January 21, 2022

RE: SafeStor Self-Storage

**Grading and Drainage Plan**

**Hydrology File: L08D013**

Drawing file: ESC / L08D013 Approved Grading Plan.pdf

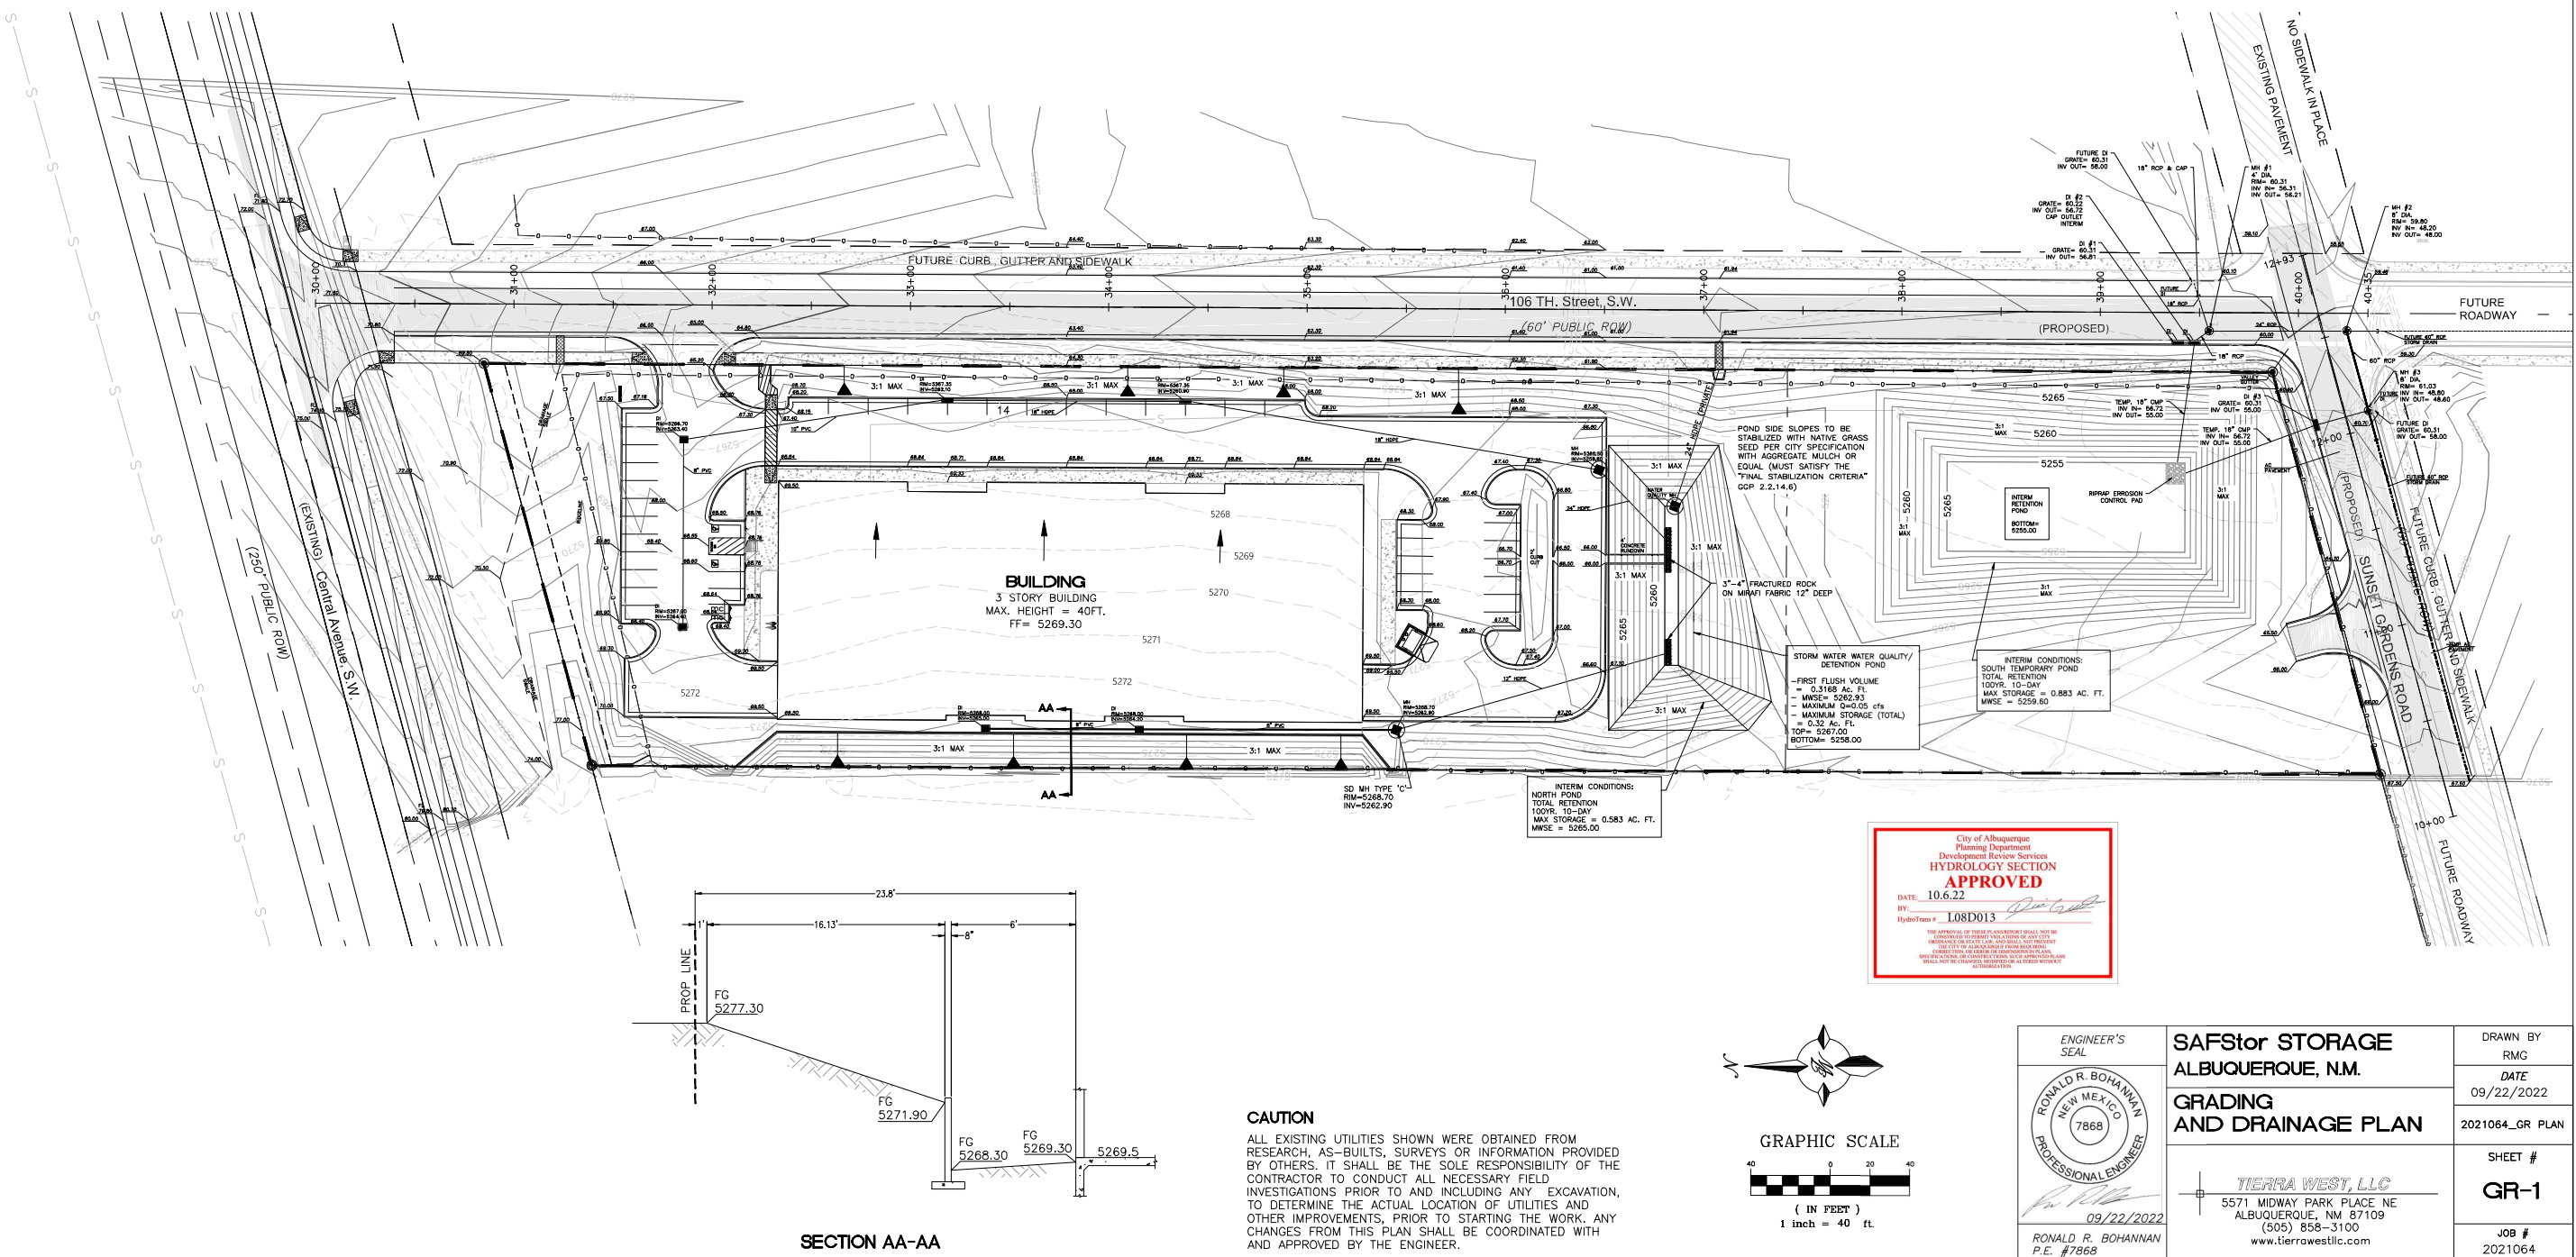
- 2. Provide elevations at the basin boundary and around the site. Also, provide elevations of existing/proposed flowlines for 106<sup>th</sup> and Central.
- 3. What is this? Outfall? (below) provide a detail of how this drainage will discharge downstream into the appropriate proposed infrastructure.

- 4. Provide survey points.
  - a. How does the proposed basins tie into eachother? Show high pt. between defined basins.
- 5. Include project benchmark and datum.
- 6. Please clean up text. Upside down and please remove dark background.

- 7. A waterblock, 0.87' high, per COA Paving Detail No. 2426, is required at the driveway entrance.
- 8. For a detention pond, please include the 100-year 24 hr. storm calculations and provide volume for that. This may require new calculations. It is not clear what is included in the calcs even though the drainage report stated 24 hr. The numbers do not match up. Please also include the 6 hour typical storm calcs and clearly label them and include the input values from DPM CH-6 Tables.
- 9. The provided drainage report references DPM chapter 22 which is not in use any longer. Please utilize the new DPM Chapter 6 and update calculations.
- 10. This appears to be a ponding area/low spot. How does this flow to pond? (see below)

- 11. Please label pipe size and materials utilized. Does 106<sup>th</sup> St. have capacity? It appears to be unpaved and will require infrastructure improvements to be made.

- a. There appears to be no downstream capacity along 106<sup>th</sup> st.
- 12. Per the IDO § 6-4(Q), the property owner of the property is responsible for building the adjacent half of 106<sup>th</sup> St. Sunset Gardens to include curb & gutter, and sidewalk. The project will have to go to the DRB for approval of the Infrastructure List which will have to financially guaranteed.

- 13. Additionally, the site will be required to adhere to the Amole Hubble Drainage Master Plan. This includes an allowed flow of 3.54 CFS per acre for the 100-year 24-hour storm event.

- 14. A section of the proposed street will be required and will need to show how the intersection will also work at 106<sup>th</sup> St. and Sunset Gardens.

- 15. Provide storm inlets to collect appropriate flow for the shown basin (see attached Amole Hubble Drainage Master Plan section). The site will be required to tie to the existing 60" storm drain and appropriately size new infrastructure to collect flow from the basin to be sized appropriately for future build out. See attached as-builts (675782) to see HGL and existing infrastructure.

- 17. Provide street section of proposed 106<sup>th</sup> and sunset Gardens per CoA standards. See attached as-builts for existing sections.
- 18. Provide hydraulic calculations for this proposed storm drain system, calculated along the Energy Grade Line; include both the HGL and EGLs in the table.

- 19. Please add a note under Grading Notes. "Side slopes need to be stabilized with Native Grass Seed (per City Spec 1012) with Aggregate Mulch or equal (Must satisfy the "Final Stabilization criteria" CGP 2.2.14.b.)".

- 21. Provide street capacity analysis demonstrating that the 100-year HGL remains at/below top of curb, and the 100-year EGL remains within the ROW. For arterial roads, one travel lane in each direction must also remain open during the 10yr storm.

22. Provide inlet calculations, including 2x capacity (50% clogging factor) for inlets in a sump. For orifice calculations, the open area (or void space) for the new bike-friendly Albuquerque grate (Dwg 2220) is 3.72sf. Please ensure you orifice calculations are updated to reflect this.
